**Exhibition of Environmental Impact Statement for SSD-105396208
New Bankstown Hospital, Bankstown**

Submission to New Bankstown Hospital Environmental Impact Statement

Canterbury-Bankstown Council Submission
May 2026

Figure 4. Proposal Diagram

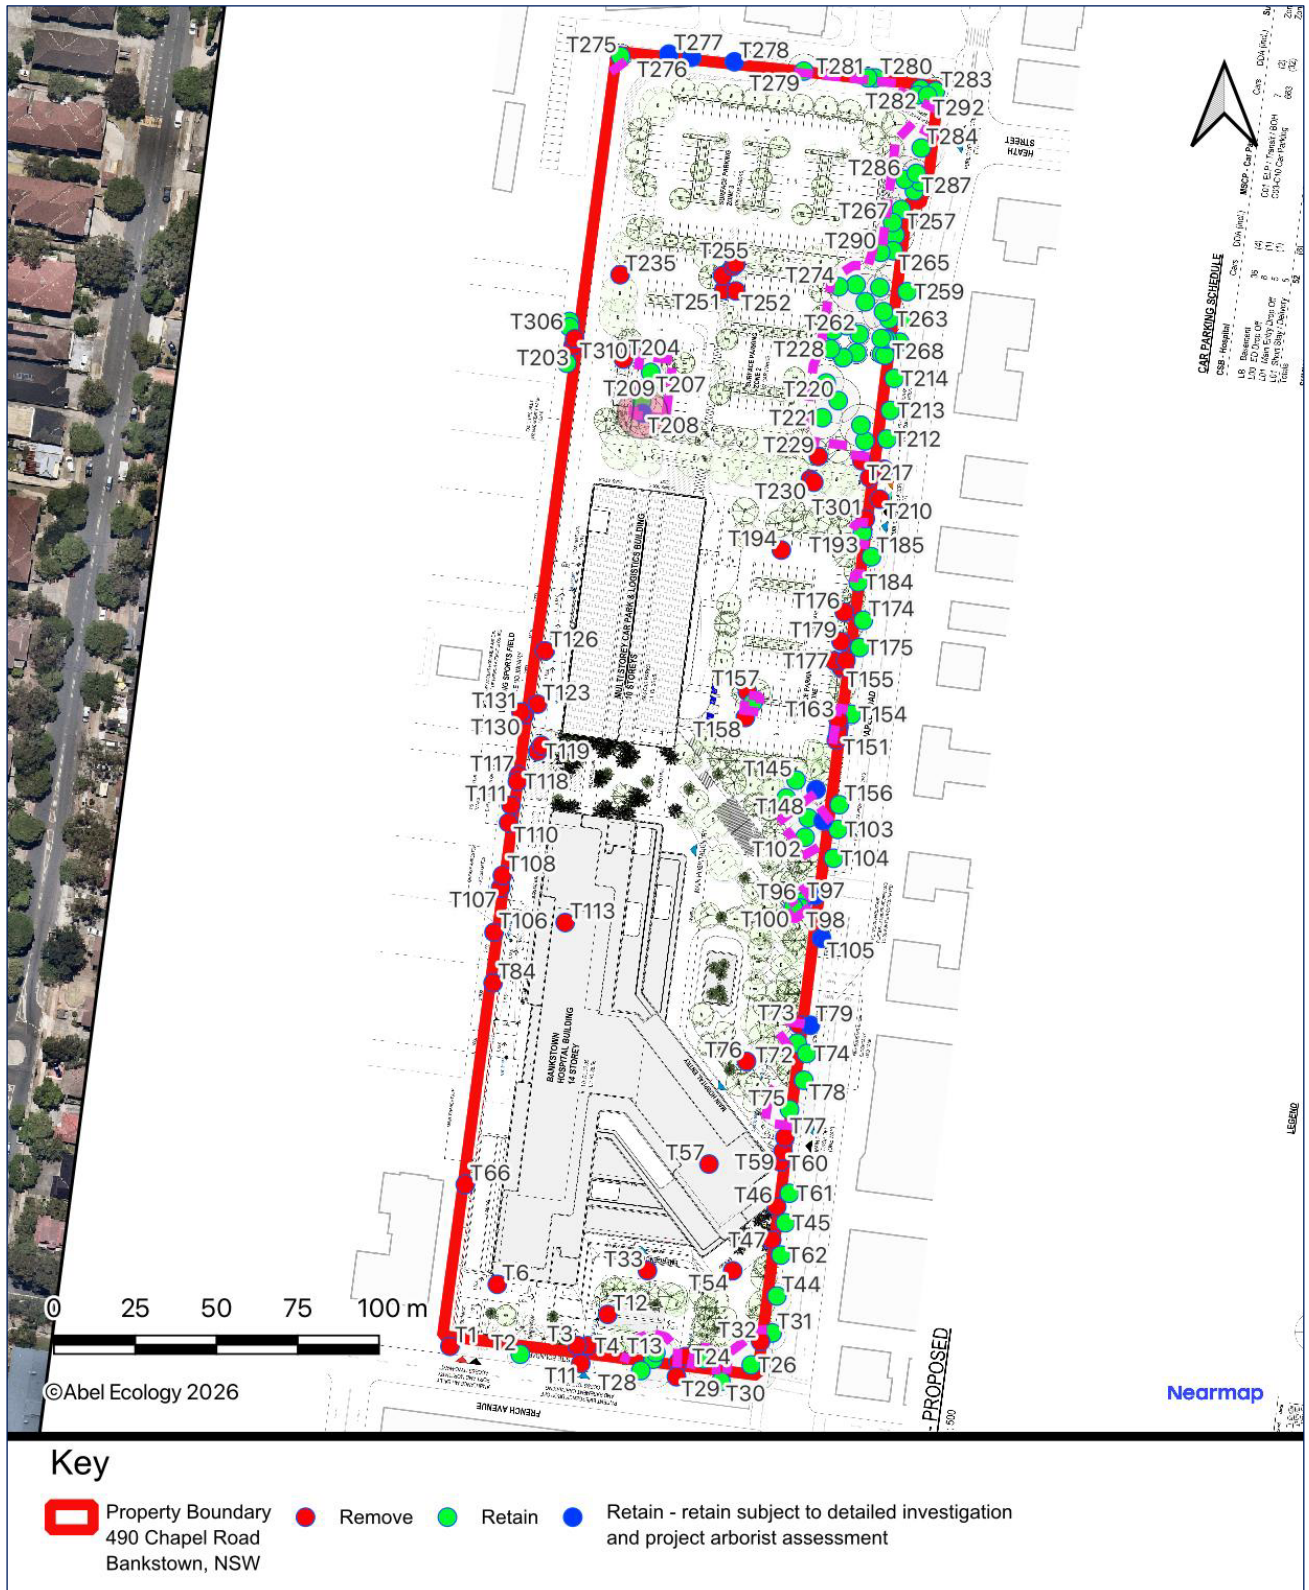
- Reconsider the need to remove the Sydney Blue Gum along French Avenue, identified as T23 in the EIS documentation.
- Provide a 3D Model of the proposed design for inclusion in Council's 3D Model Portal and to assist with assessment of future surrounding development. A link to requirements is available at <https://www.cbcity.nsw.gov.au/planning-and-building/development-and-building/development-applications>
